THE SIZEWELL C PROJECT

POST HEARING SUBMISSIONS INCLUDING WRITTEN SUBMISSIONS OF ORAL CASE SUBMITTED BY THE HEVENINGHAM HALL ESTATE

TRAFFIC AND TRANSPORT

DRAWING TITLE:
NORTHERN PARK AND RIDE
PROPOSED PARAMETER PLAN

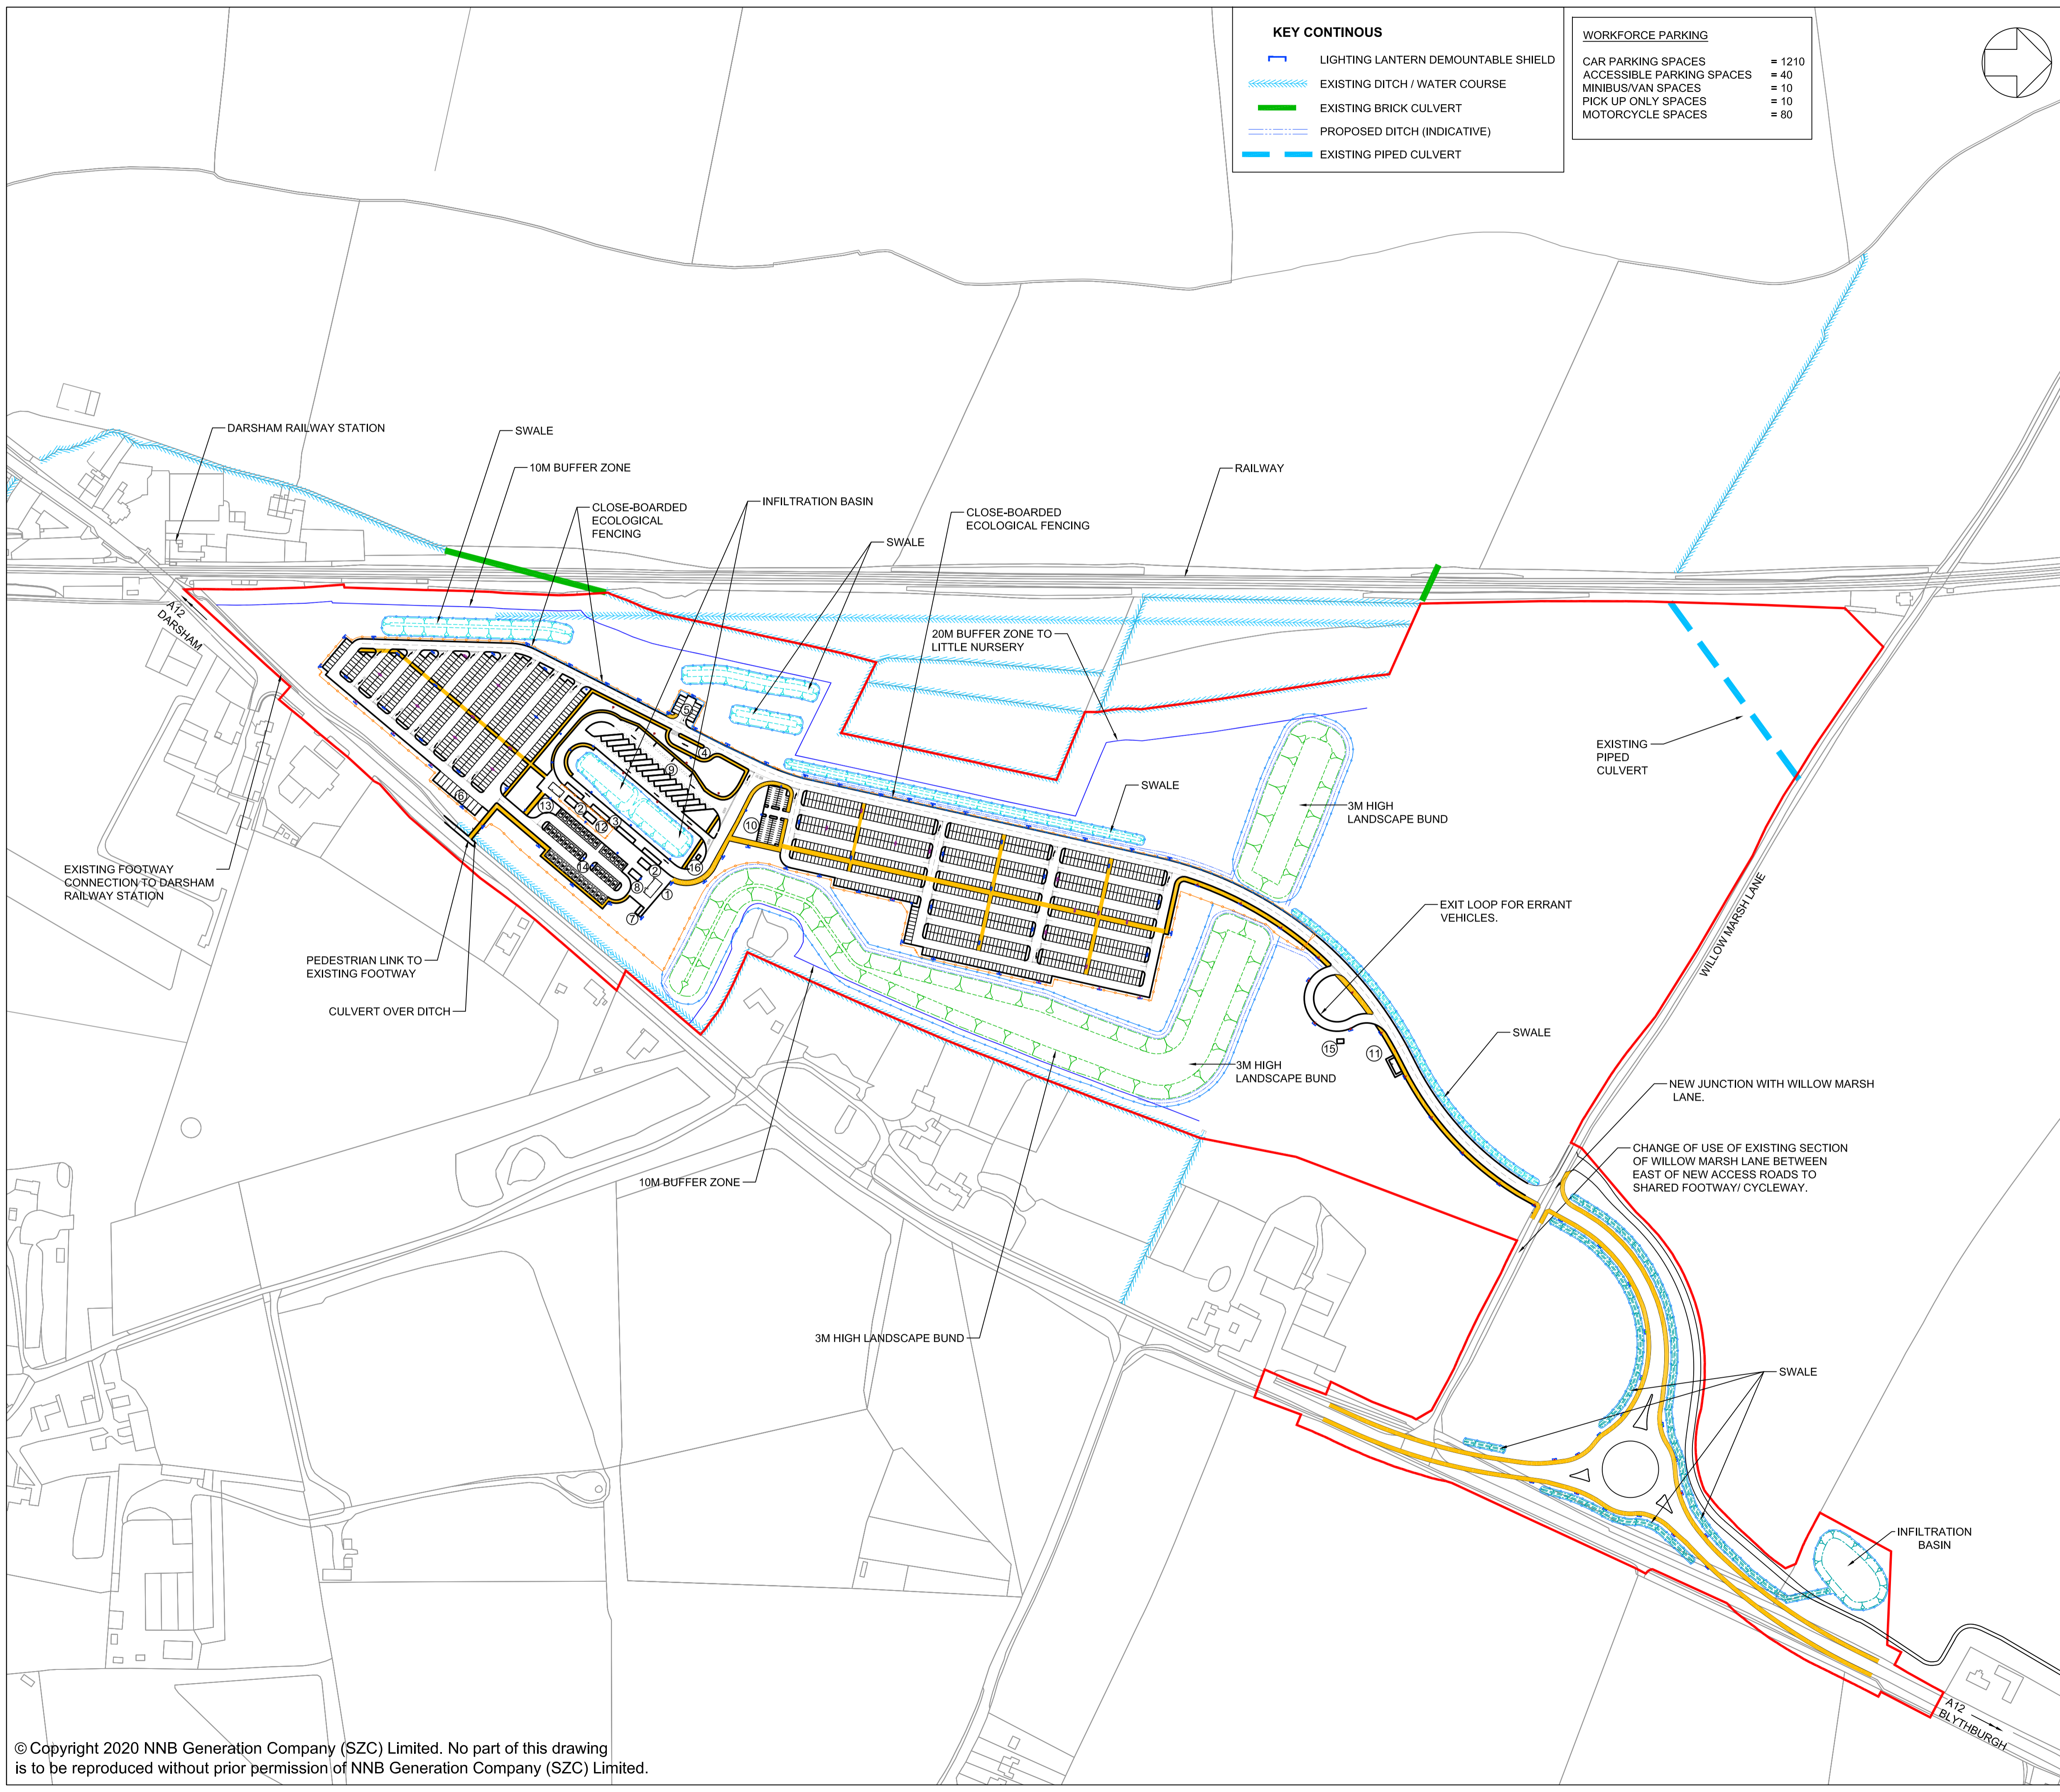
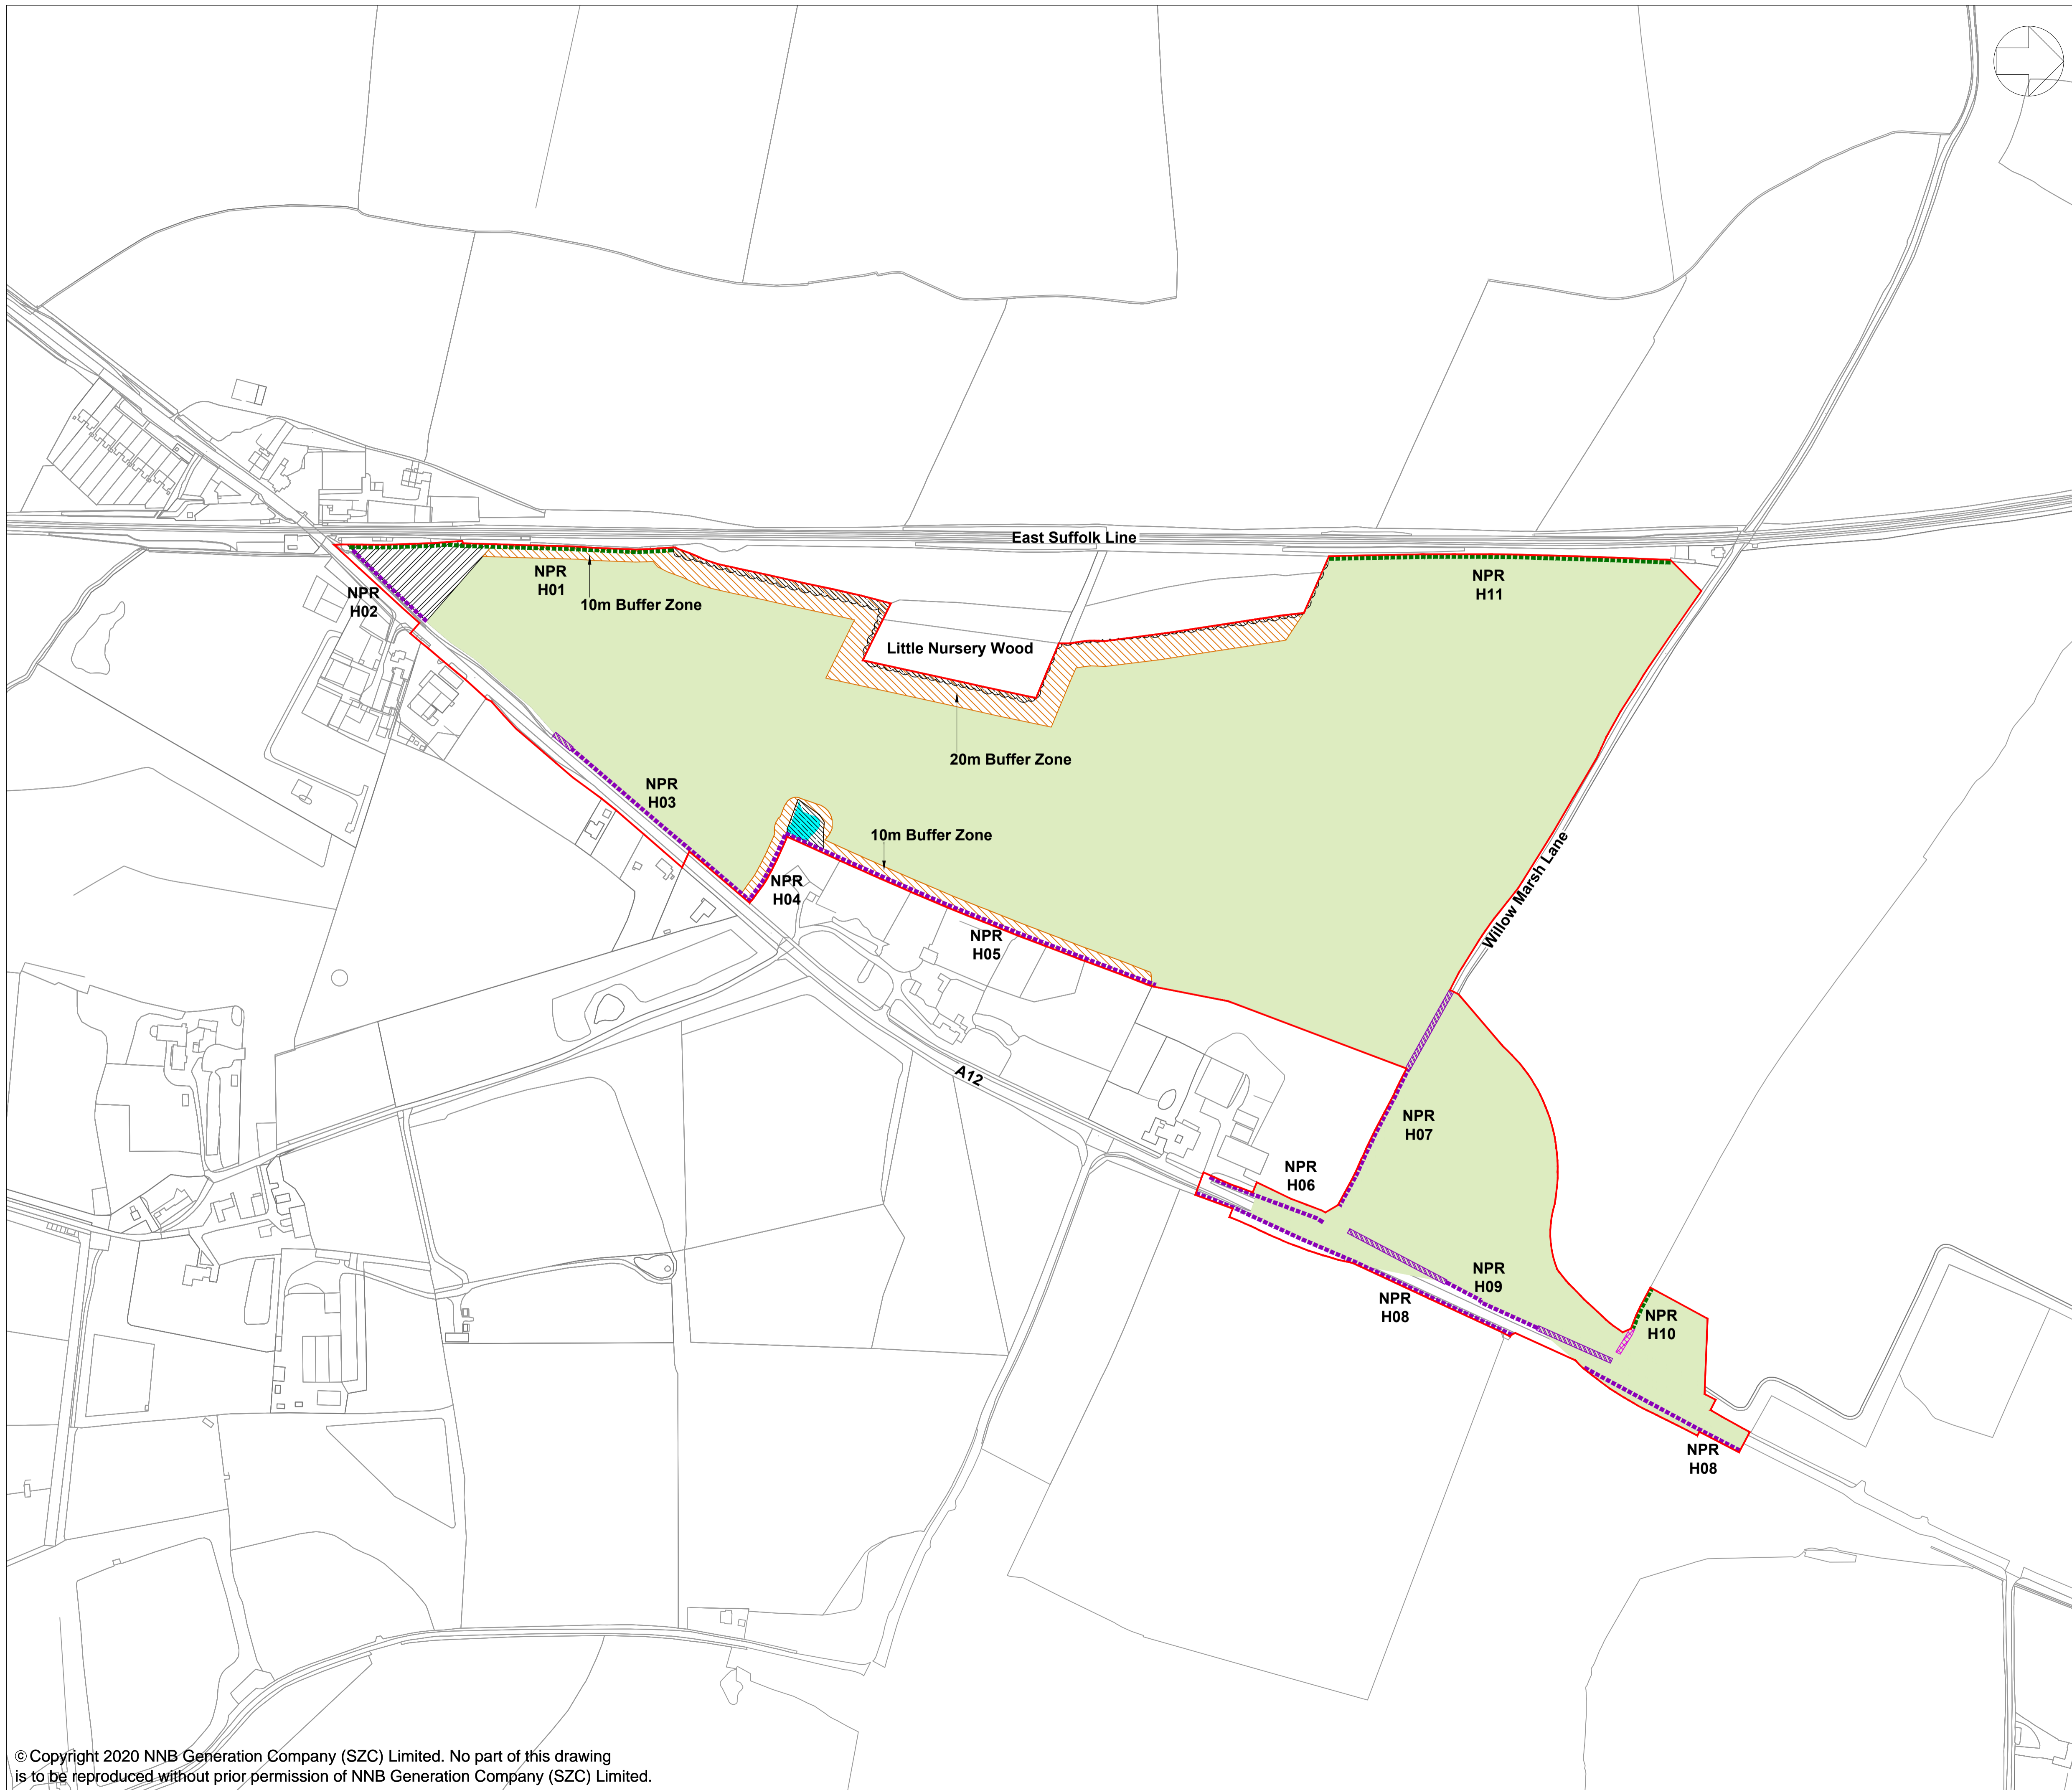
- (d) Finally, an effective CWTP that directs workers to use a particular park and ride site negates the need for a 15-20% buffer of "spare" parking spaces. Unlike a public car park, SPR and NPR users would not have to drive around looking for parking and could instead use a designated space that they know will be available. The Applicant's suggestion in its D3 Response that one of the reasons for extra space is to prevent drivers queuing onto the highway network is frankly risible when one looks at the actual design of the NPR, specifically the layout of the car park, the long route leading to it and the loop for errant vehicles.

- (b) the Applicant revisits the justification for the size of the NPR in light of the approach highlighted in the CWTP i.e. that the Applicant will require workers to use a specific mode of transport.
